APPLICATION NO. 03-02149	PROJECT NO. 1003009
PROJECT NAME JEFFERSON COMMONS JOHNNY & CARINOS	
EPC APPLICATION NO.	
APPLICANT / AGENT TIERRA WEST	PHONE NO. 858.3100
ZONE ATLAS PAGE F-17	
(SDP for SUB), (SDP for BP), (FINAL PLATS), (MASTER DEV PLAN), (IR), (AA)	
<b>ONE STOP COMMENT FORM LOG</b>

DRB Application No.: 03-02149  
Project Name: Jefferson Commons  
EPC Application No.: \_\_\_\_\_  
Phone No.: 858-3100

**TO:** Sheran Matson, DRB Chair  
**FROM:** Carmen Marrone, Staff Planner  
**RE:** **Project #1003009**, Site Plan for Building Permit,  
Johnny Carinos Restaurant, I-25/Jefferson NE

JEFFERSON COMMONS-II JOHNNY CARINOS	DRAWN BY DM
	LANDSCAPE PLAN	DATE 12-18-2003
	TERRA WEST, LLC 8509 JEFFERSON NE ALBUQUERQUE, NEW MEXICO 87113 (505) 858-3100	230095LS-121703.DWG
	4 OF 6	SHEET #
		JOB # 230095

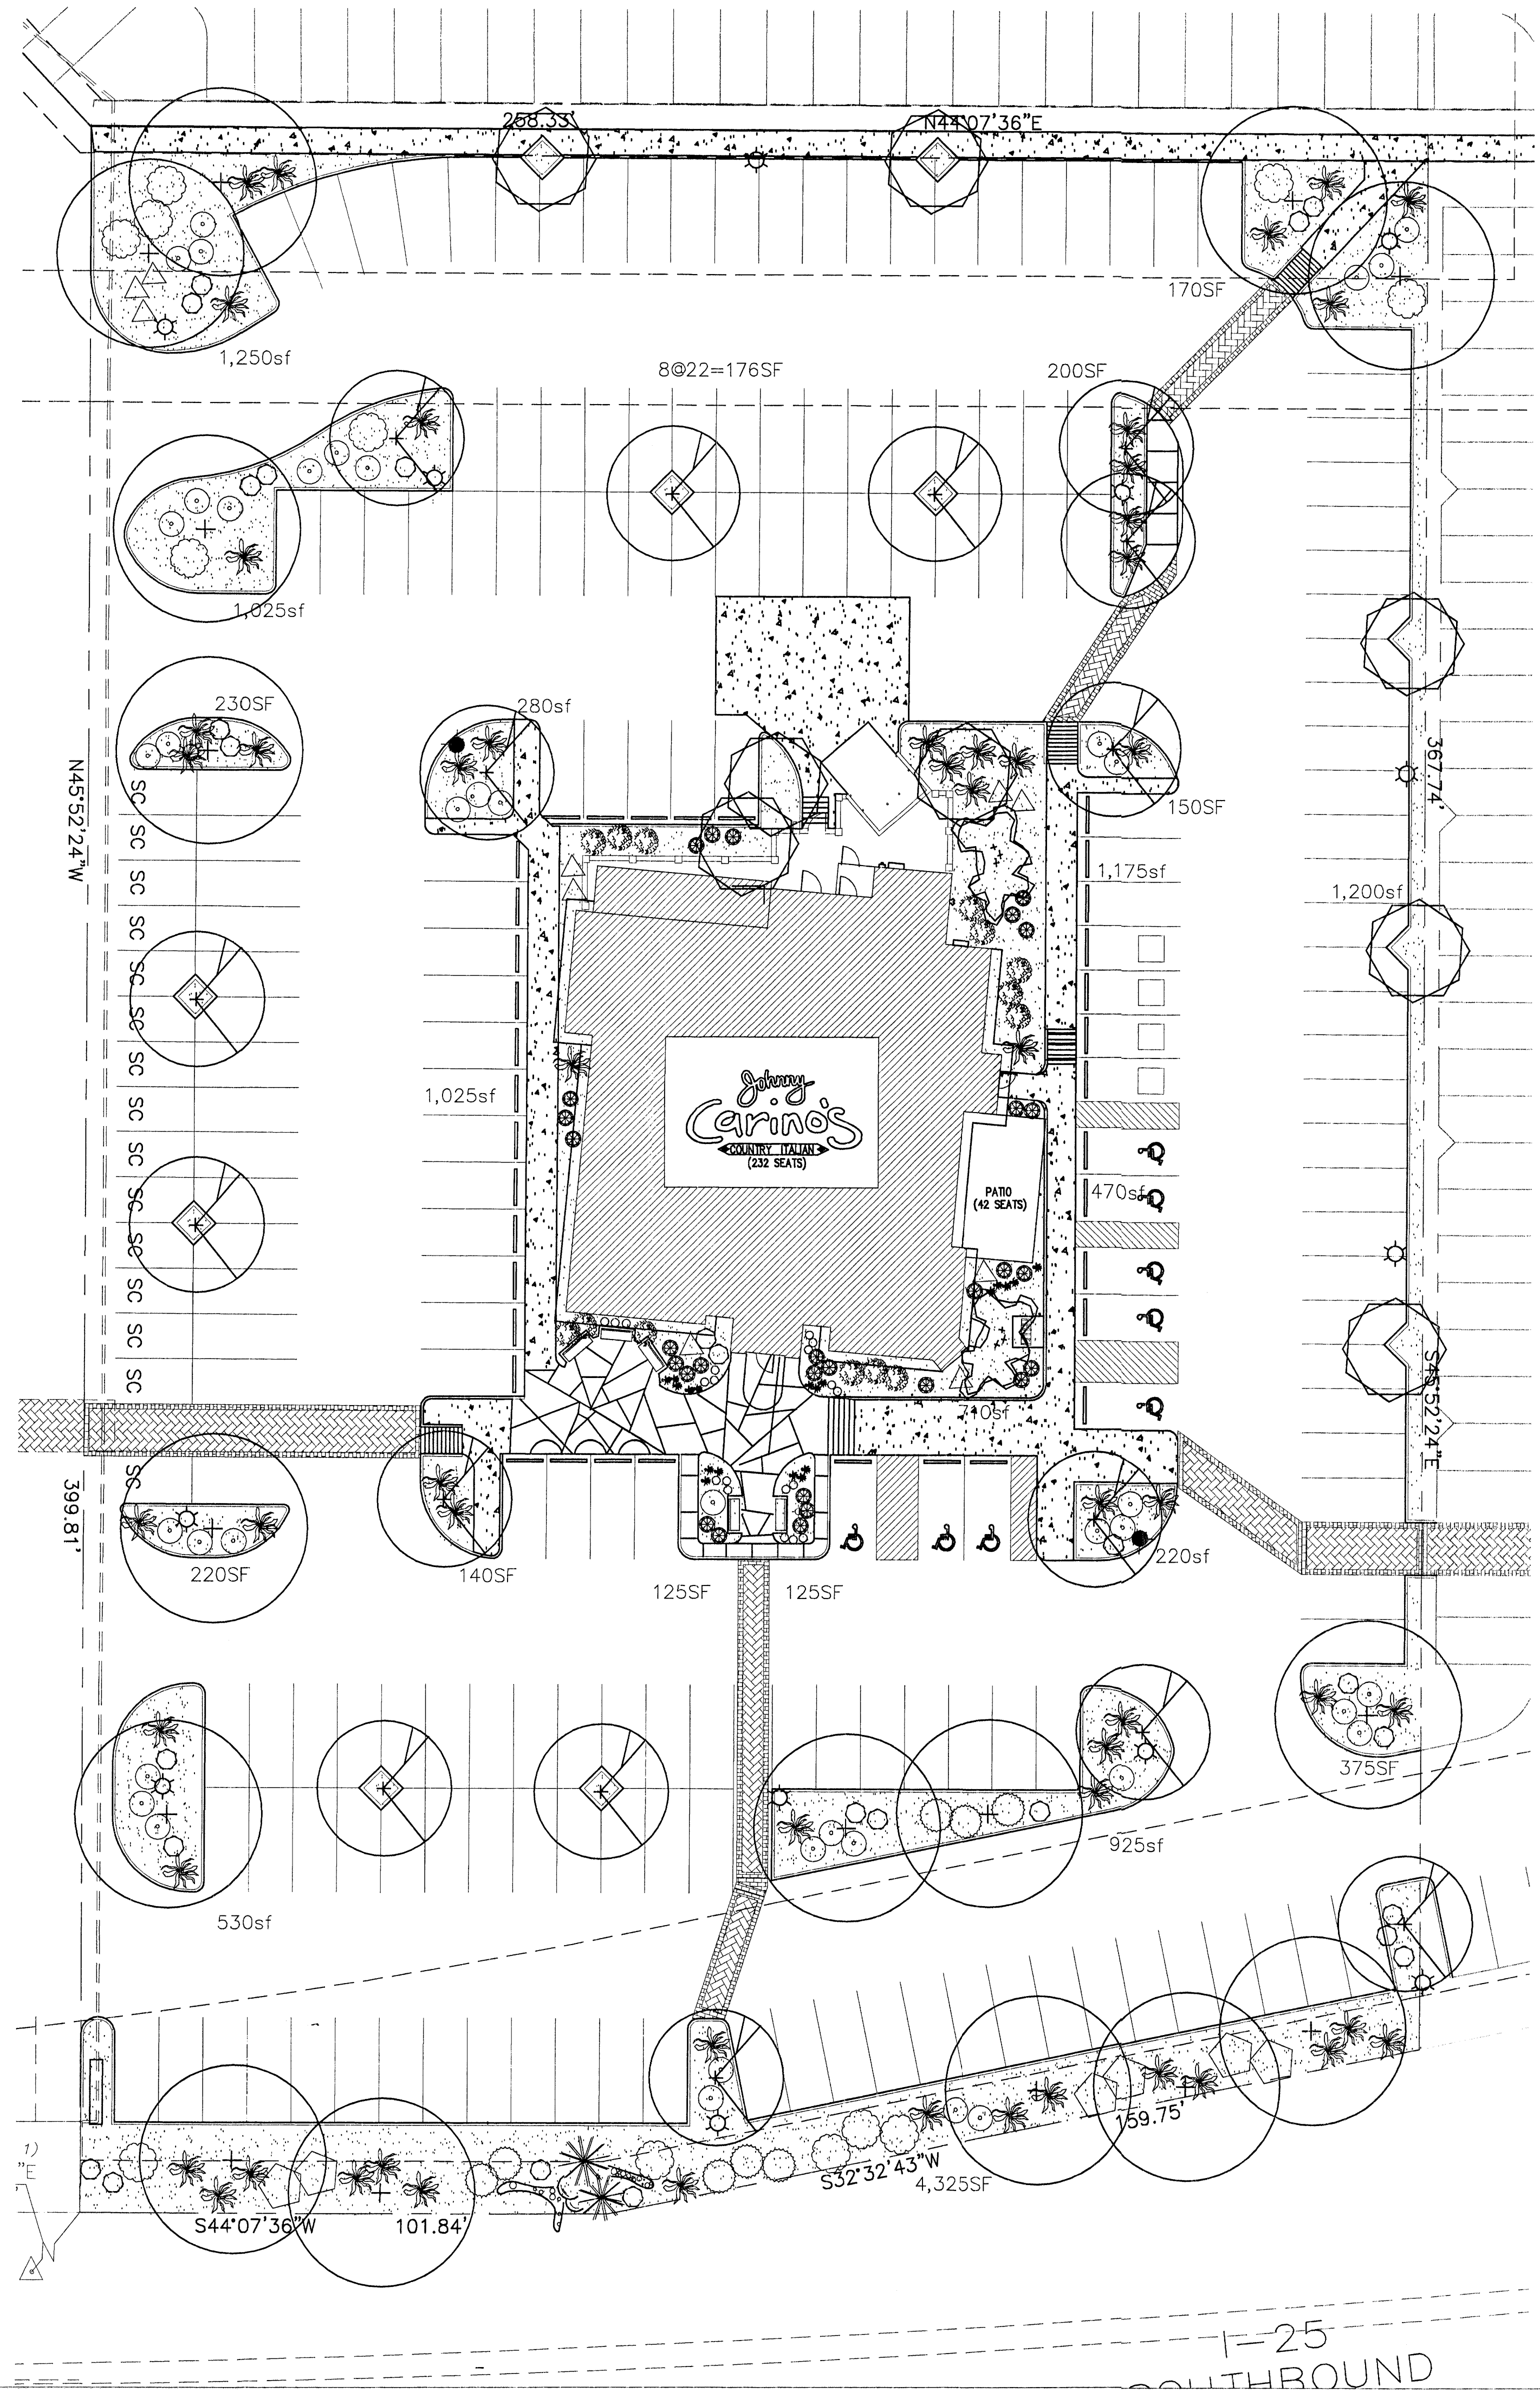
The site plan for building permit for this project was approved by the EPC on November 20, 2003 with conditions. I have reviewed the latest submittal and find that the applicant has met all of the conditions imposed by the EPC except for Condition #4c. The Master Plan that controls this site lists theme shrubs to provide continuity throughout the larger site (see attached). The proposed Landscape Plan only lists 2 theme shrubs out of a total of 9 species of shrubs proposed. The applicant shall add Cliffrose, Silverberry, Spanish Broom, and/or Santolina to meet the intent of the Master Plan.

PLANNING (Last to sign) Add plants per woman's comment 12/31/03  
 Planning must record this plat. Please submit the following items:  
 -The original plat and a mylar copy for the County Clerk.  
 -Tax certificate from the County Treasurer.  
 -Recording fee (checks payable to the County Clerk). RECORDED DATE: \_\_\_\_\_  
 -Tax printout from the County Assessor.  
 Include 3 copies of the approved site plan along with the originals.  
 County Treasurer's signature must be obtained prior to the recording of the plat with the County Clerk.  
 Property Management's signature must be obtained prior to Planning Department's signature.  
 Copy of final plat AND a DXF File for AGIS is required.  
 Copy of recorded plat for Planning.
